From: Carol Reynolds
Sent: 03 October 2018 10:18
To: Anita Gardner
Cc: Planning.Responses
Subject: FW: Planning Consultation on: FG/52/18/PL

Environmental Health: I refer to the Acoustic Report produced by 'Sound Planning,' Project Number, J03270, dated 6th August 2018. No changes are noted in Additional Noise Documents Supplementary, 22ND August 2018.

APPLICATION NO: **FG/52/18/PL**

Description of Works: Amendments to design approved under FG/95/16/PL, polytunnels, outdoor growing beds, tree nursery, storage & welfare facilities for a horticultural enterprise.

5.2 Delivery/Unloading Noise Measurements (Near Field Mock Test)

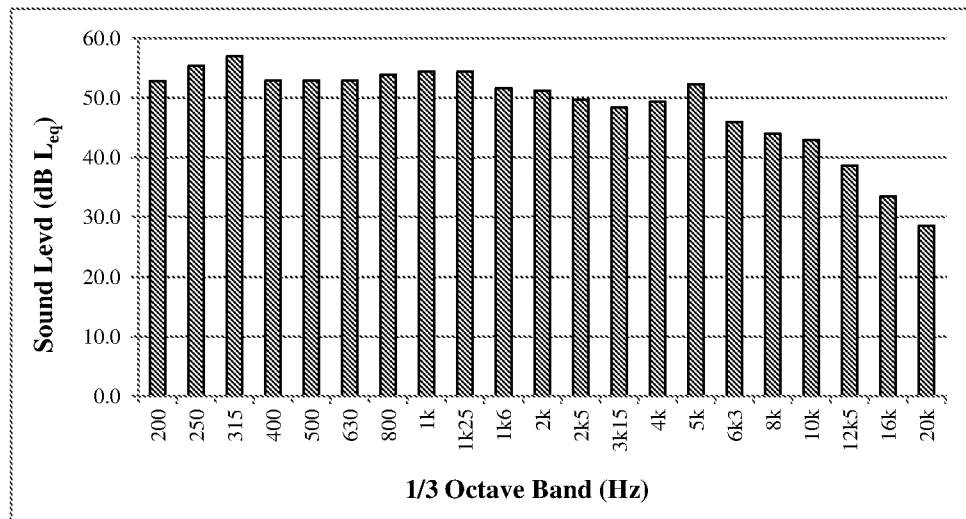
Firstly, a 'mock' delivery exercise held during daylight hours and using a 'light' (LGV) rather than 'heavy' (HGV) goods vehicle. The resulting Noise Rating Level is likely to underestimate the actual noise as it is affected by higher daytime ambient noise levels; it was an LGV rather than an HGV (and also delivery probably takes less time) and is carried out under supervised ie 'best case', conditions.

*144 Littlehampton Road
- Graph*

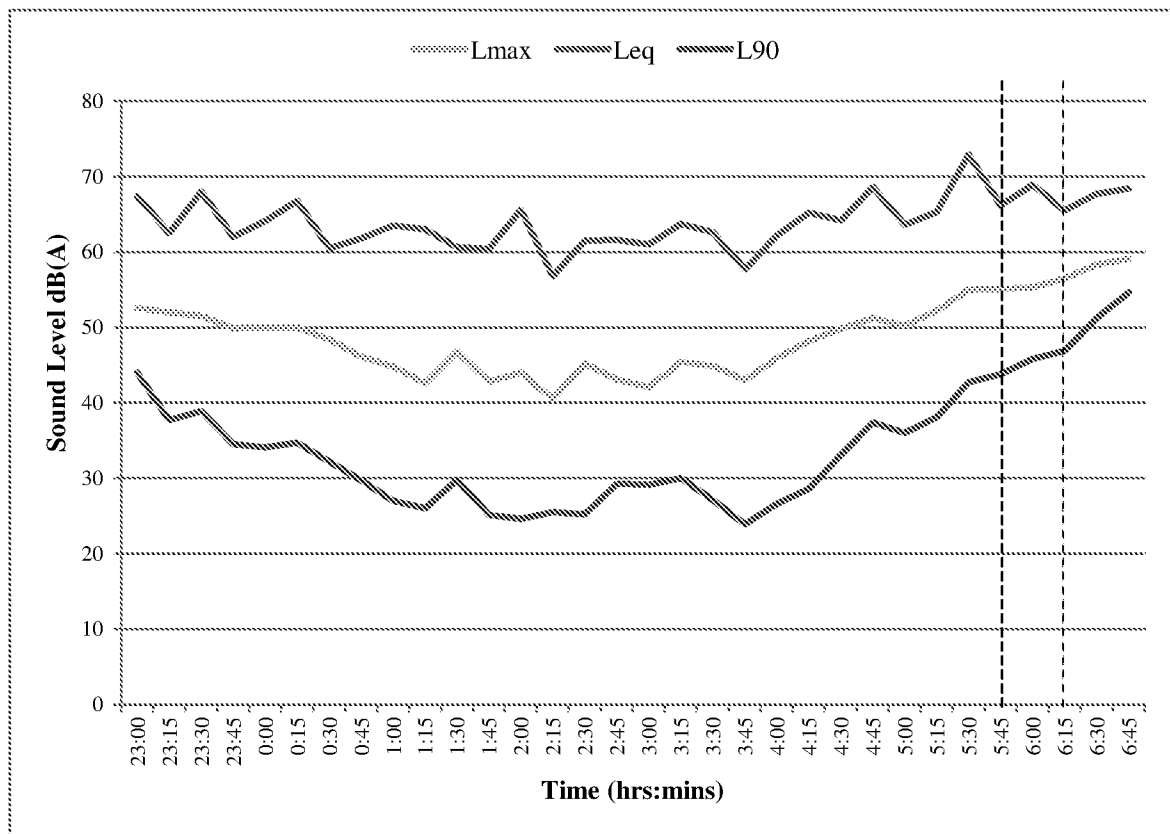
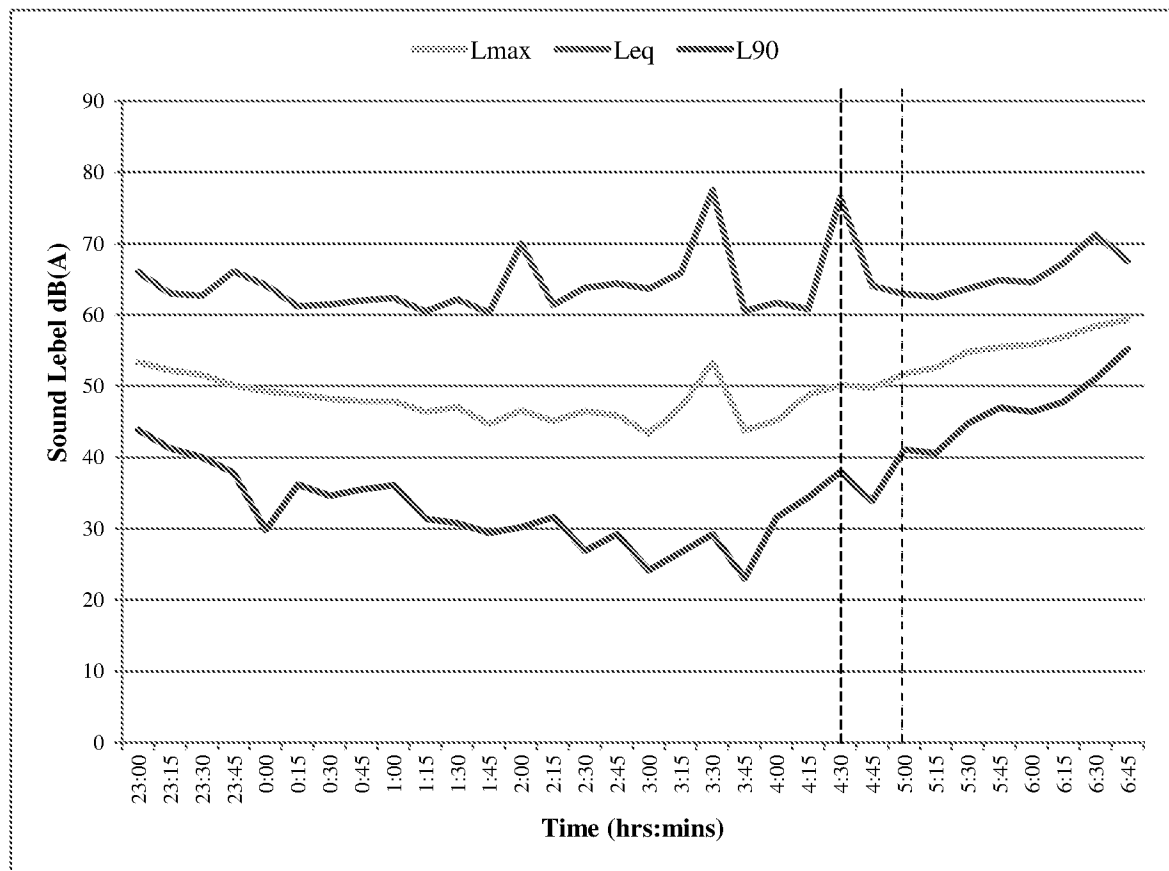
It is noted that this underestimated LGV Noise Rating Level of 37dBA, is still appreciably higher than the background noise level (LA90) of 25dB at 02:00hours when HGV deliveries can take place.
